PLANNING CONSULTATION RESPONSE

Application No	2026/0362
Proposal	Building Extension
Address	4 Hazelwood
Date of Consultation Reply	4/6/2006
Consultee	Jo Newing

FENCE 1800MM ABOVE GARDEN LEVEL
BUILT ON TOP OF NEW RETAINING WALL

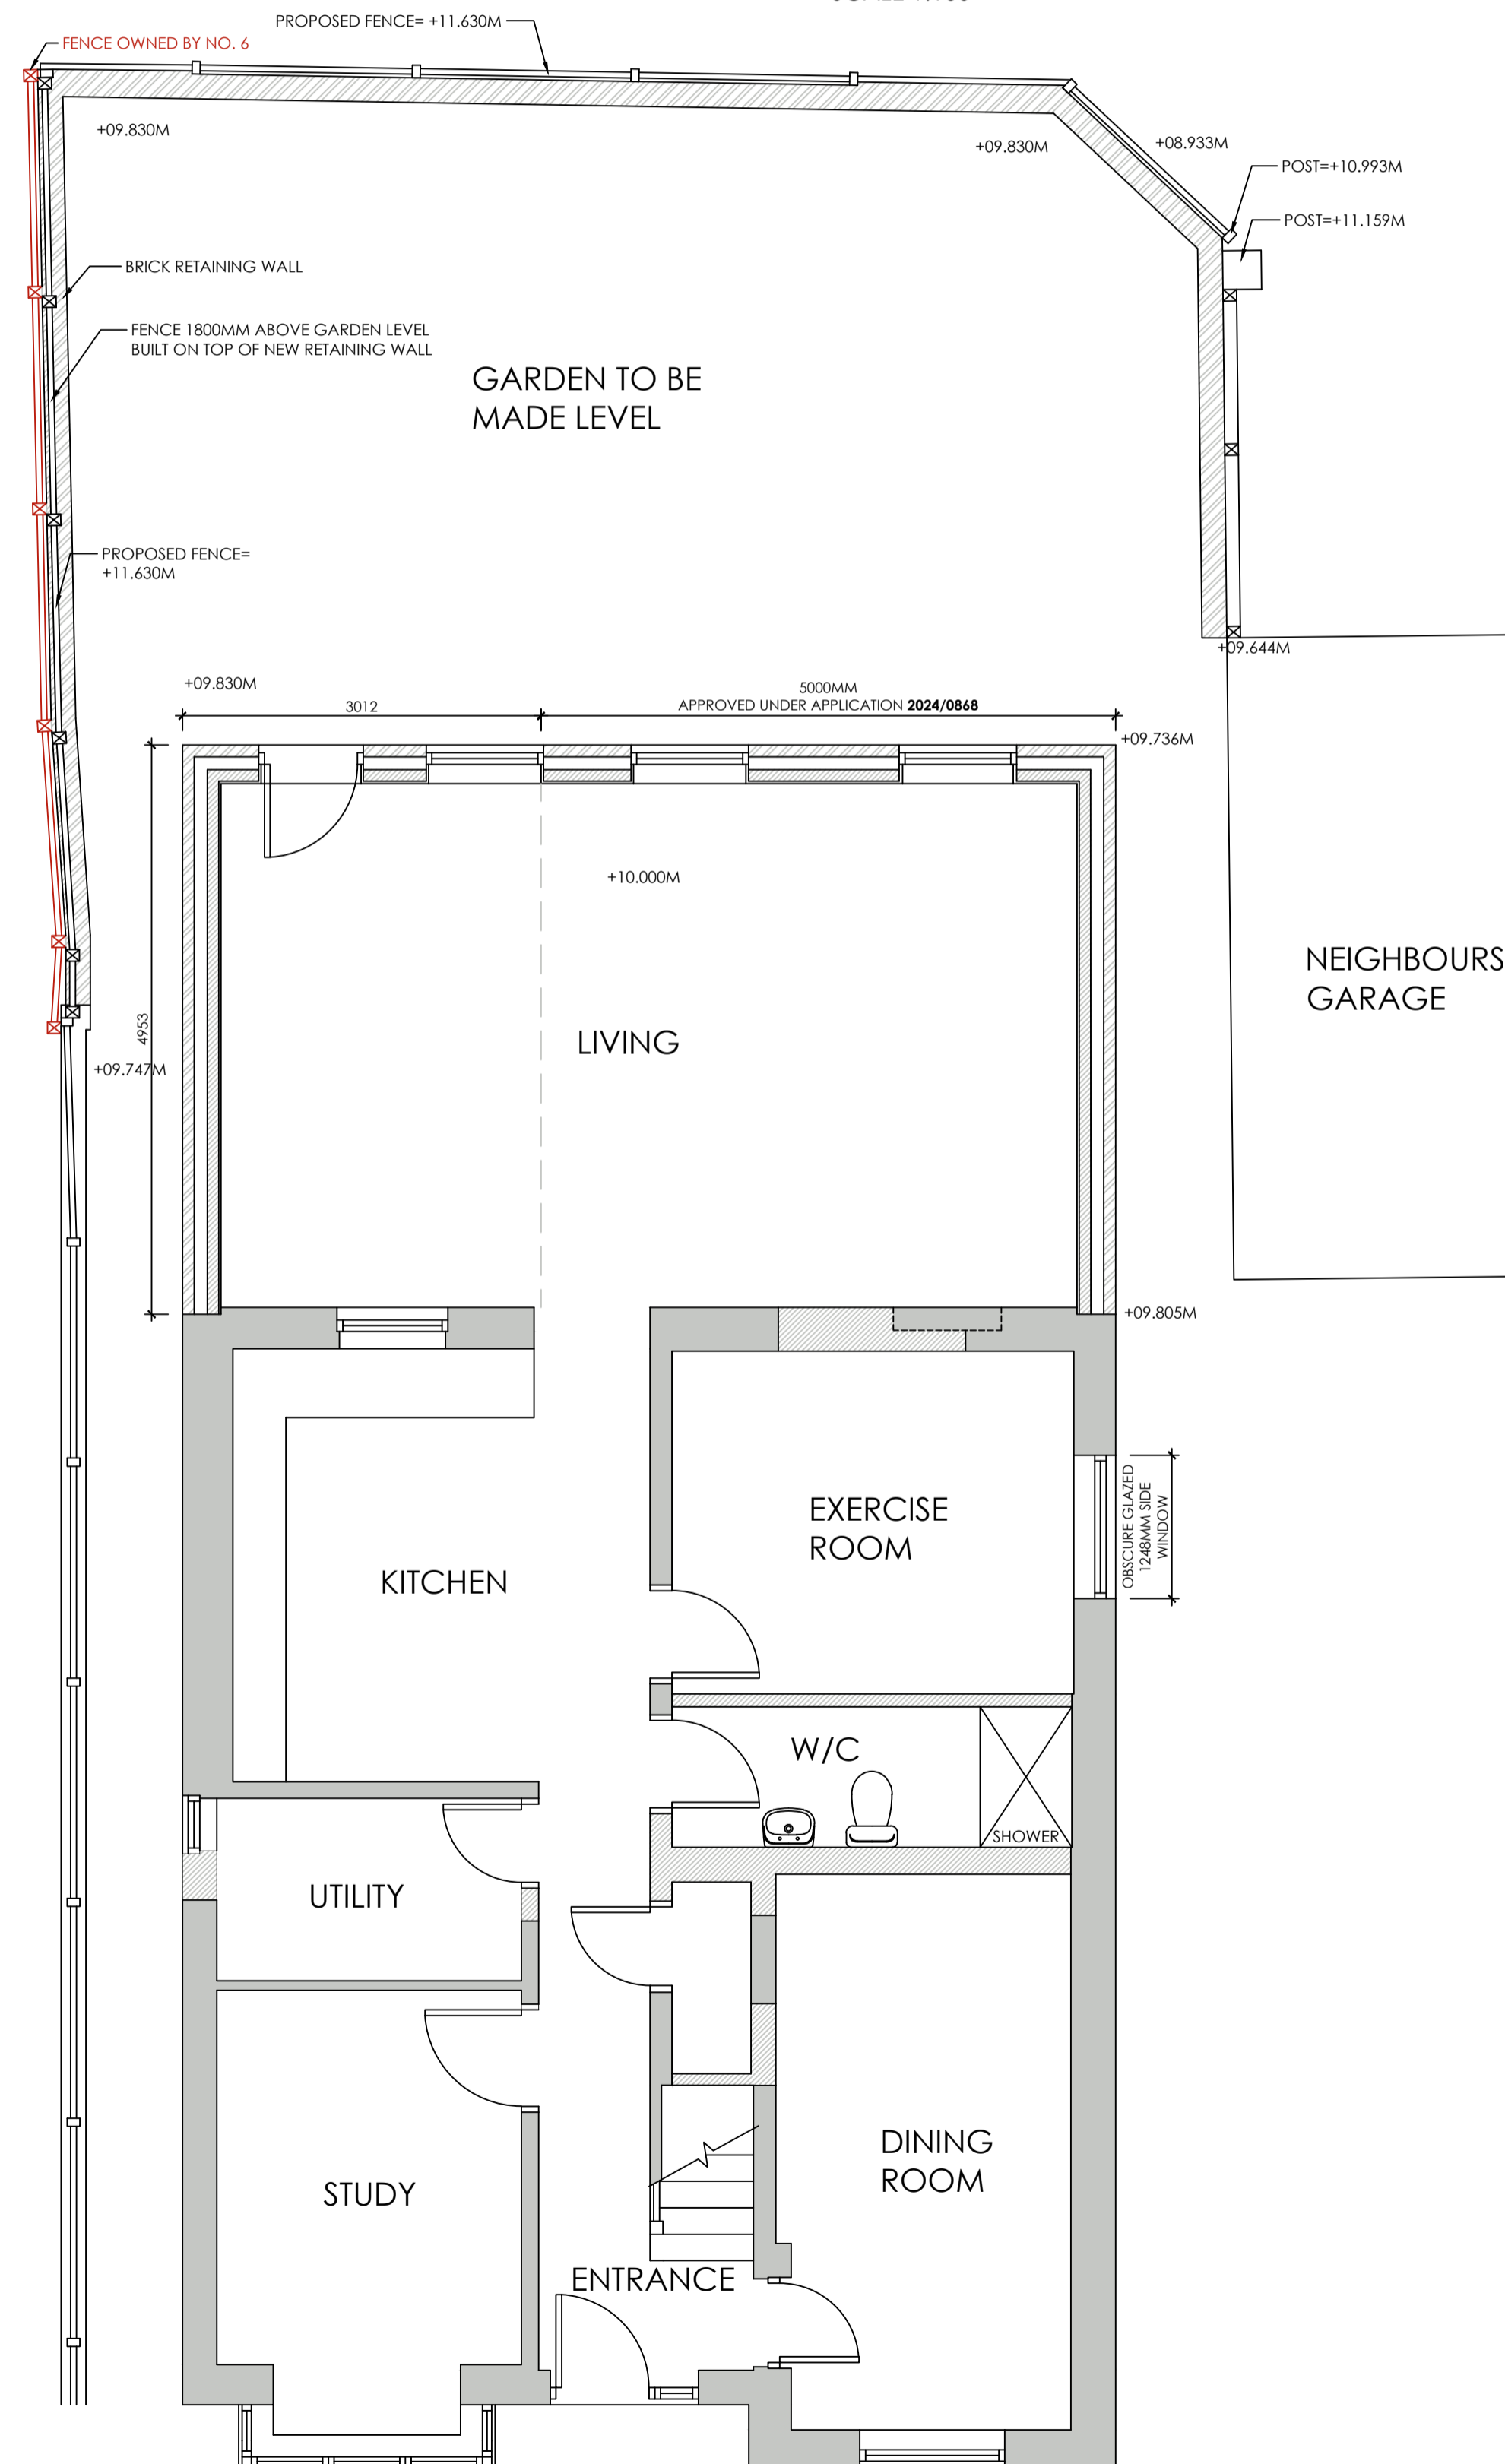
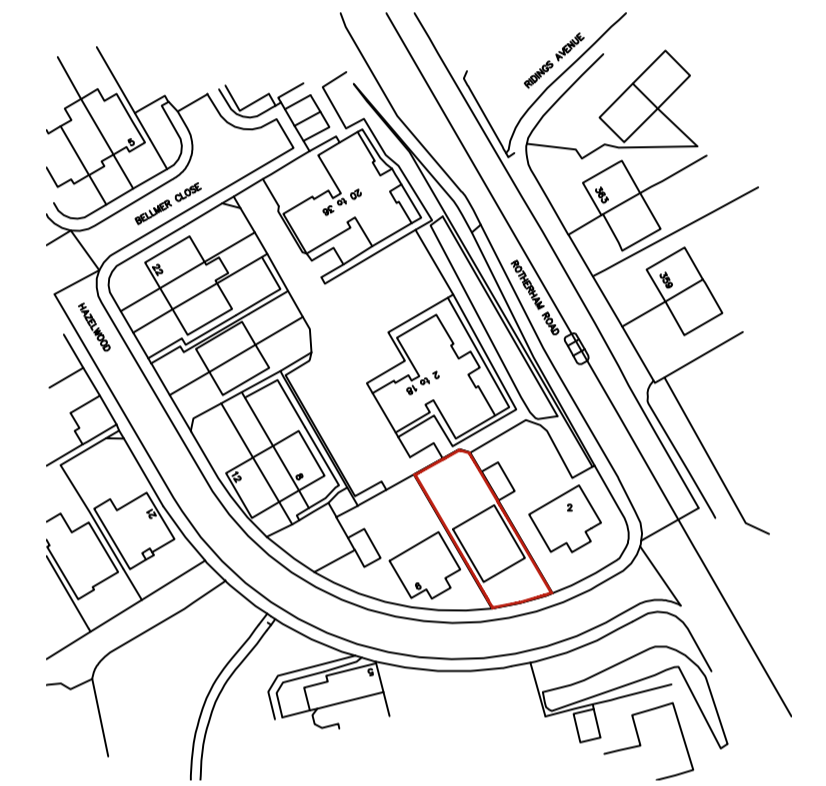
- I am concerned that the large mound in the garden, which is full of mixed rubble, and detritus from the build, is only going to be levelled with flags put on top of it, this will then be much higher than the adjoining neighbour's garden, which will mean that the neighbour will be overlooked, leading to their loss of privacy. This has already occurred when someone stood on top of the rubble and could see over into the neighbour's living room. I also have concerns regarding run-off from this mound when there is heavy rain.
